From: Kim Leslie [REDACTED]
Sent: 12 April 2019 07:19
To: Planning
Subject: Planning Application FP/46/19/PL

Planning Application FP/46/19/PL - 28 Sea Drive, Felpham

We write with reference to this planning application involving a proposed amendment to existing consent FP/205/18/HH.

PROPOSED SOUTH ELEVATION 1:100

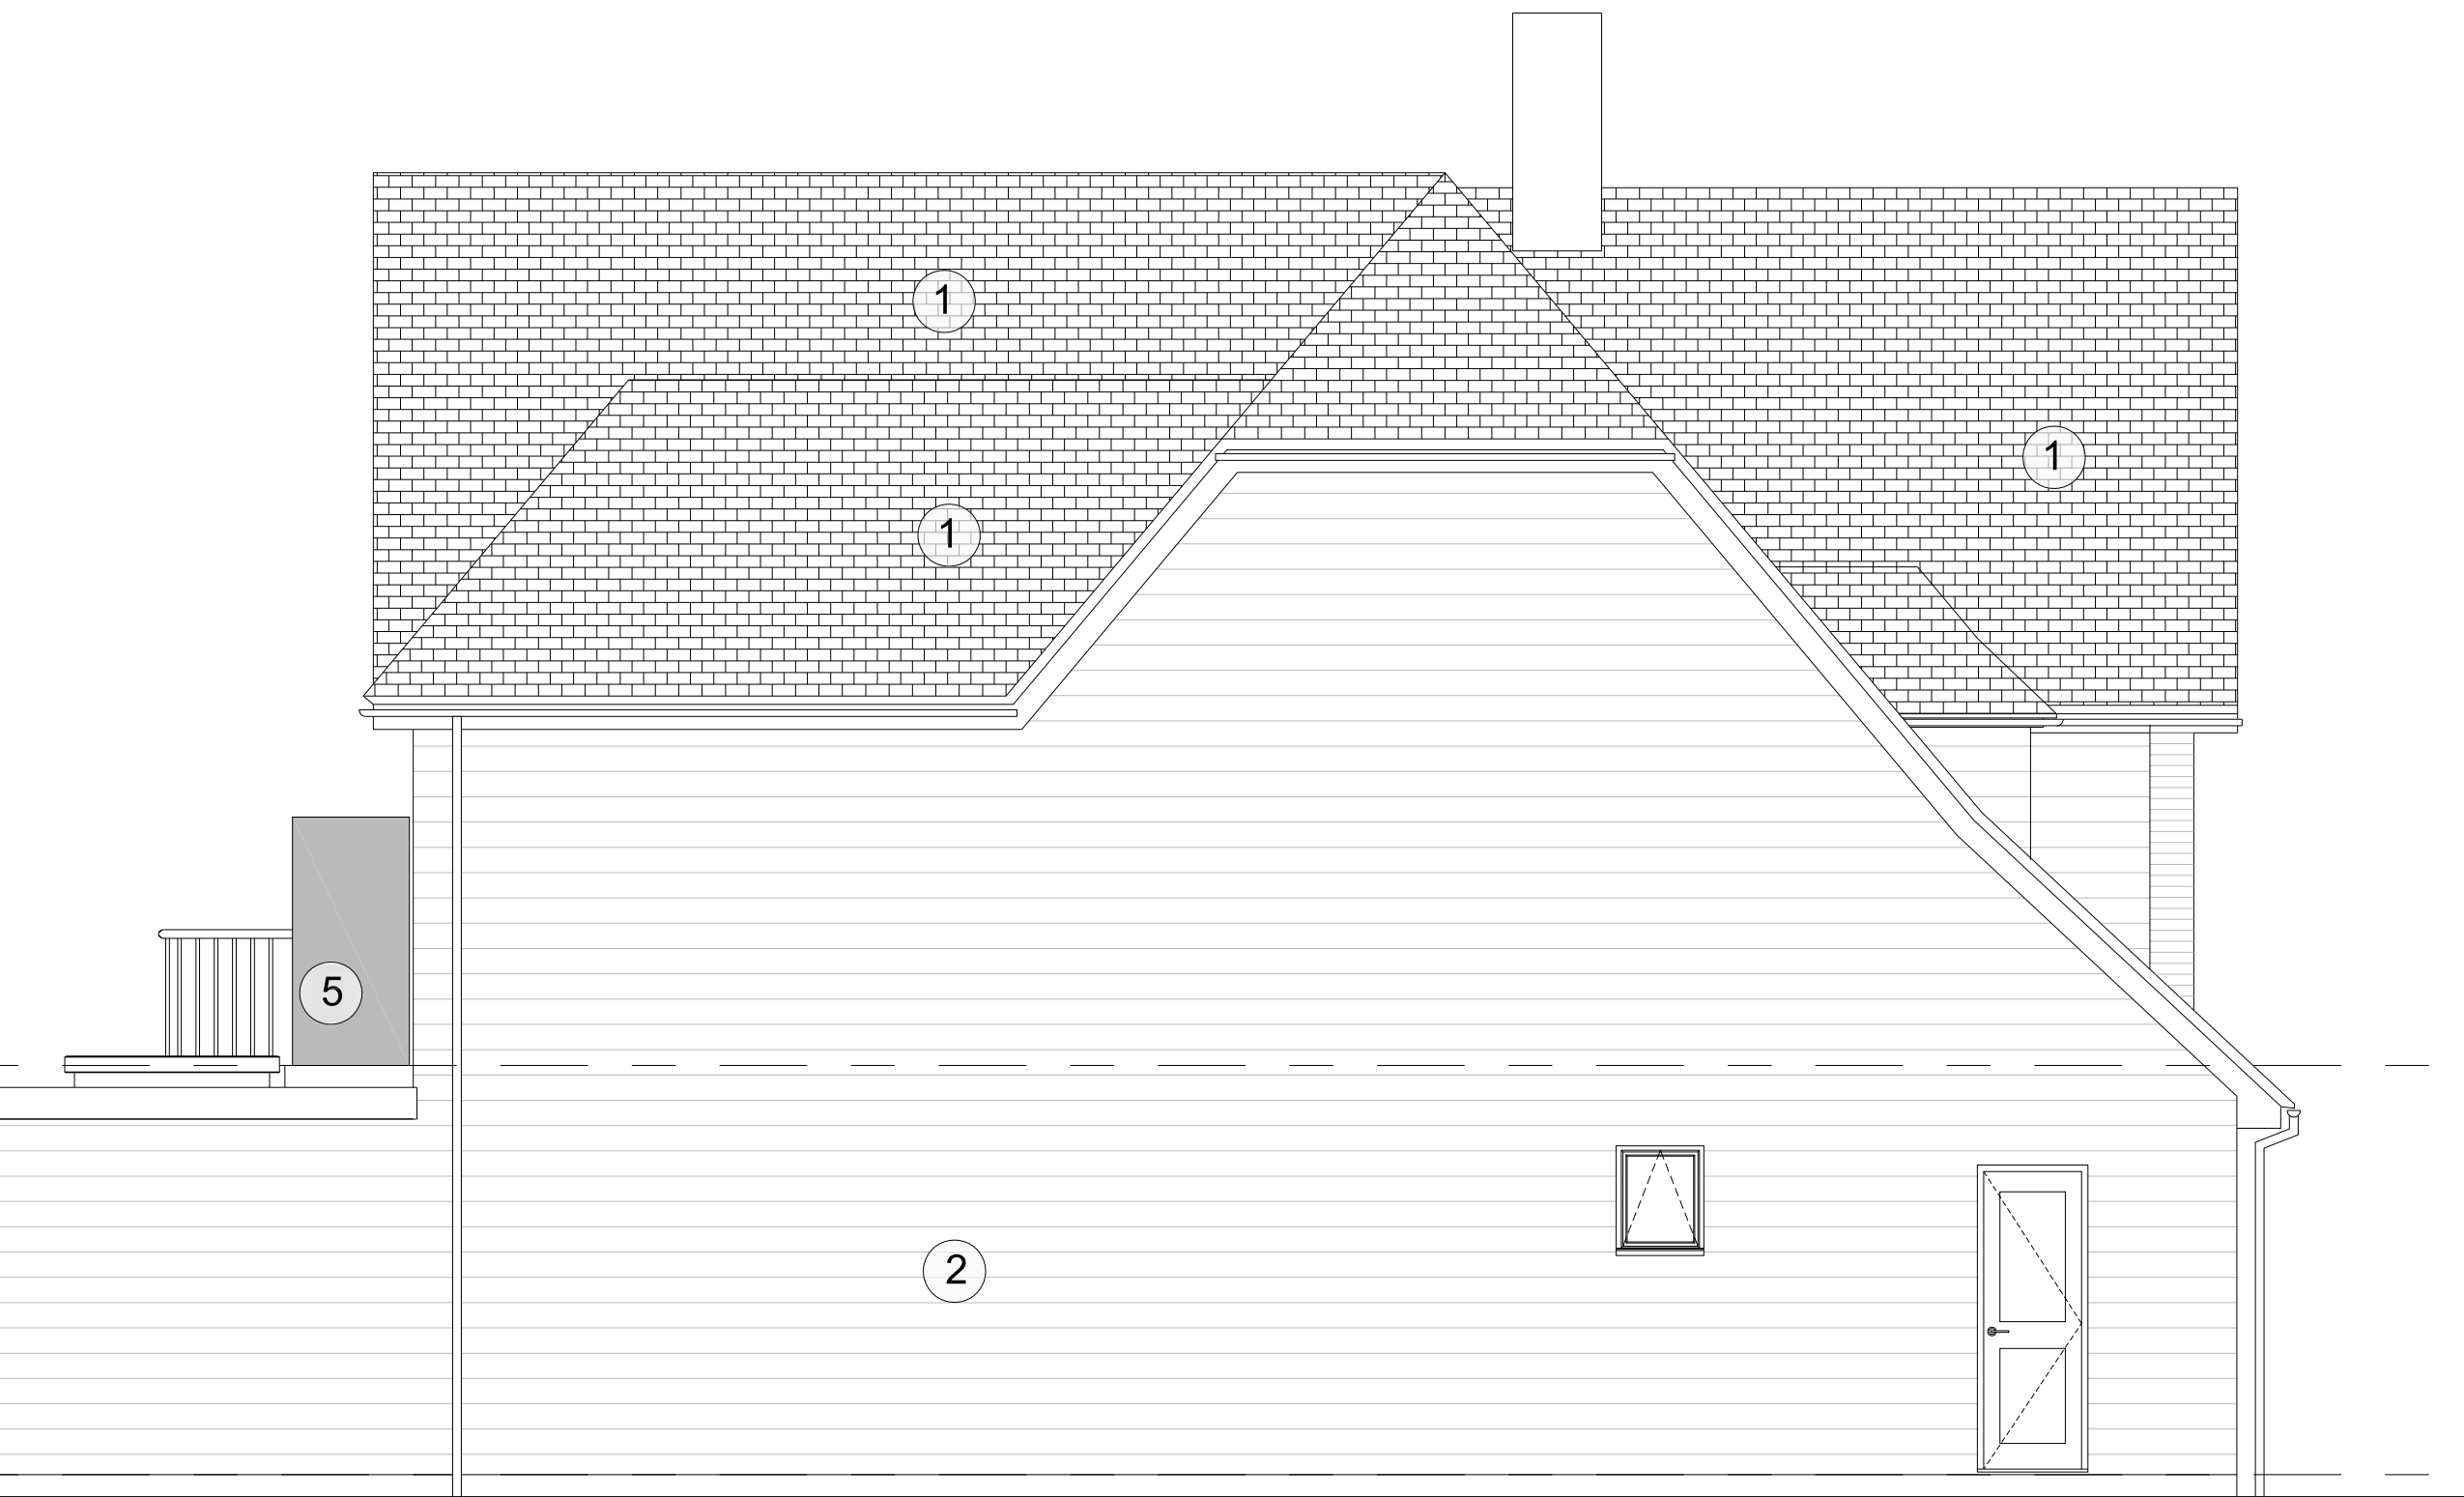
This latest proposal is misleading as the block plan and elevation plan are at variance with each other.

We note that the proposed west and east elevations indicating obscured glass panels at each end show that only half their length are drawn at full height, the other half of each end is shown at half this height which again compromises our privacy.
